PROJECT TITLE: NURSING HOME GRADE DRAIN ZONE ATLAS/DRNG. FILE #: K-15/DSO

RE: DRAINAGE PLAN FOR HORIZON NURSING CENTER
(K-15/D50) RECEIVED JUNE 16, 1989

RE: DRAINAGE PLAN FOR HORIZON NURSING CENTER
(K-15/D50) RECEIVED MAY 10, 1989

GRADING AND
DRAINAGE PLAN

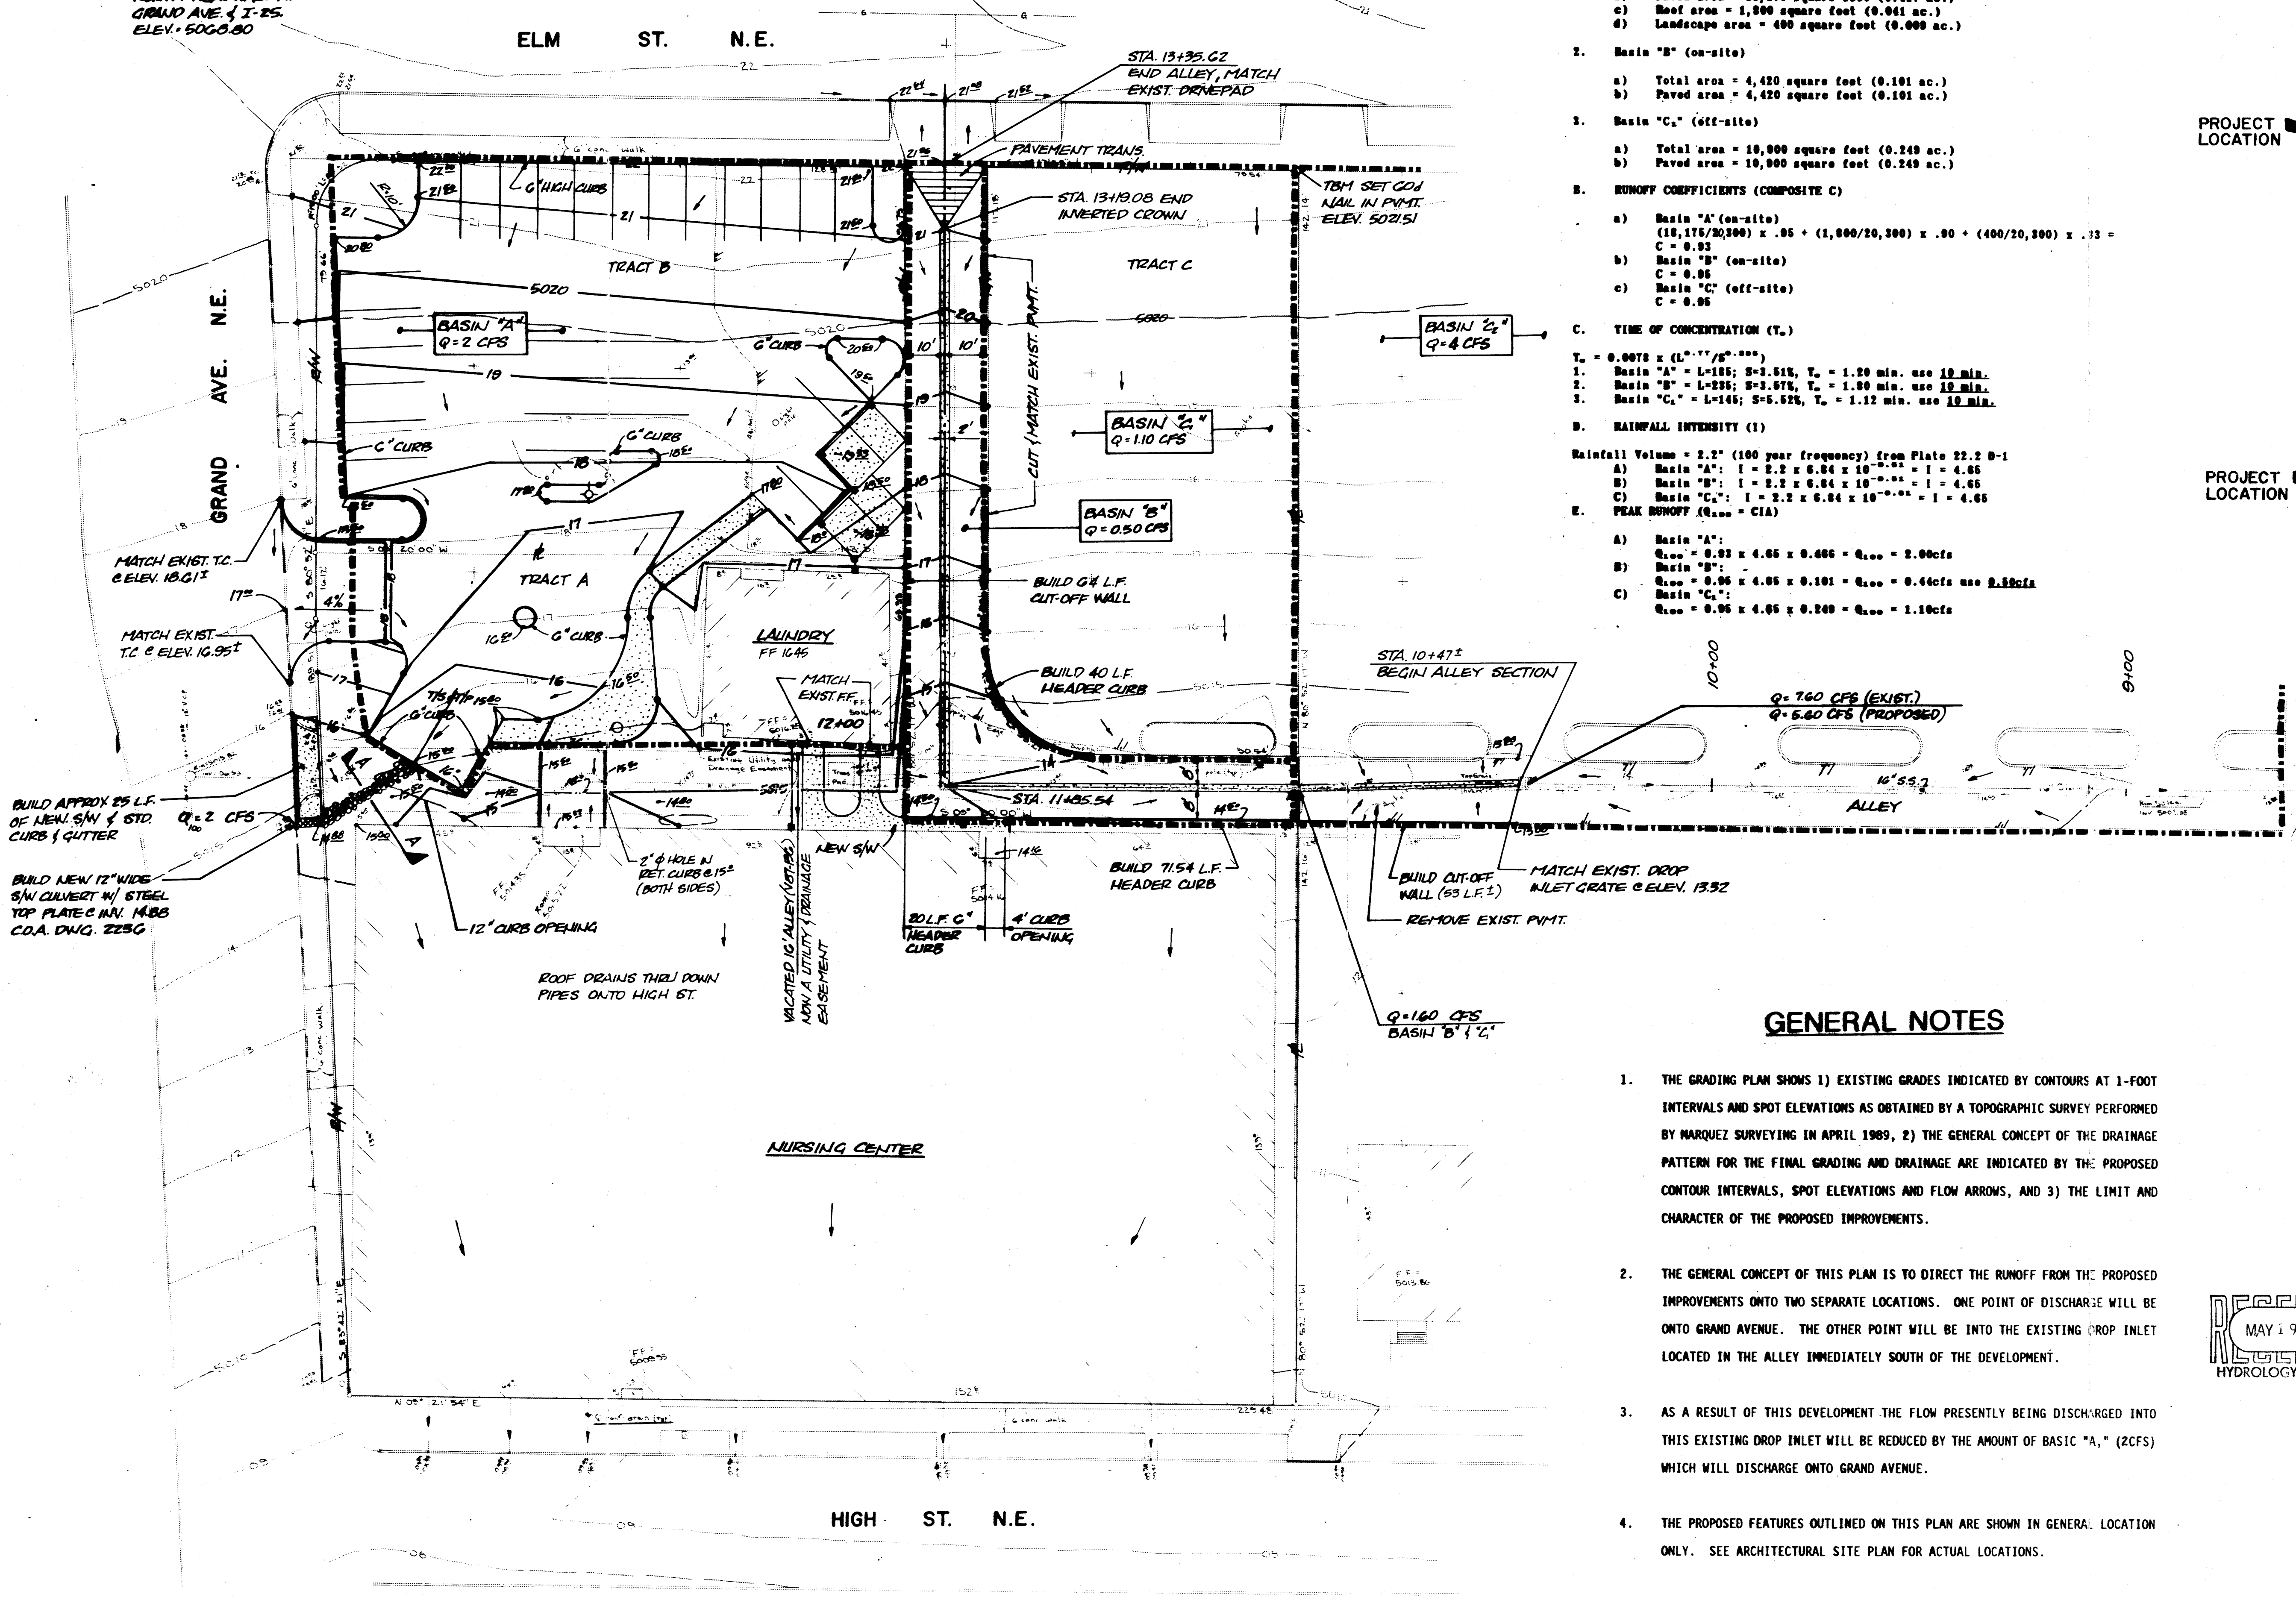
- ✓ 1. Please show roof drain.
- ✓ 2. Need a one foot water block for the entrance from Grand Avenue.
- ✓ 3. Please show where there is a 6" curb.
- ✓ 4. Will there be new curb and gutter at the sidewalk culvert area? *yes*
- ✓ 5. Please correct your time of concentrations.
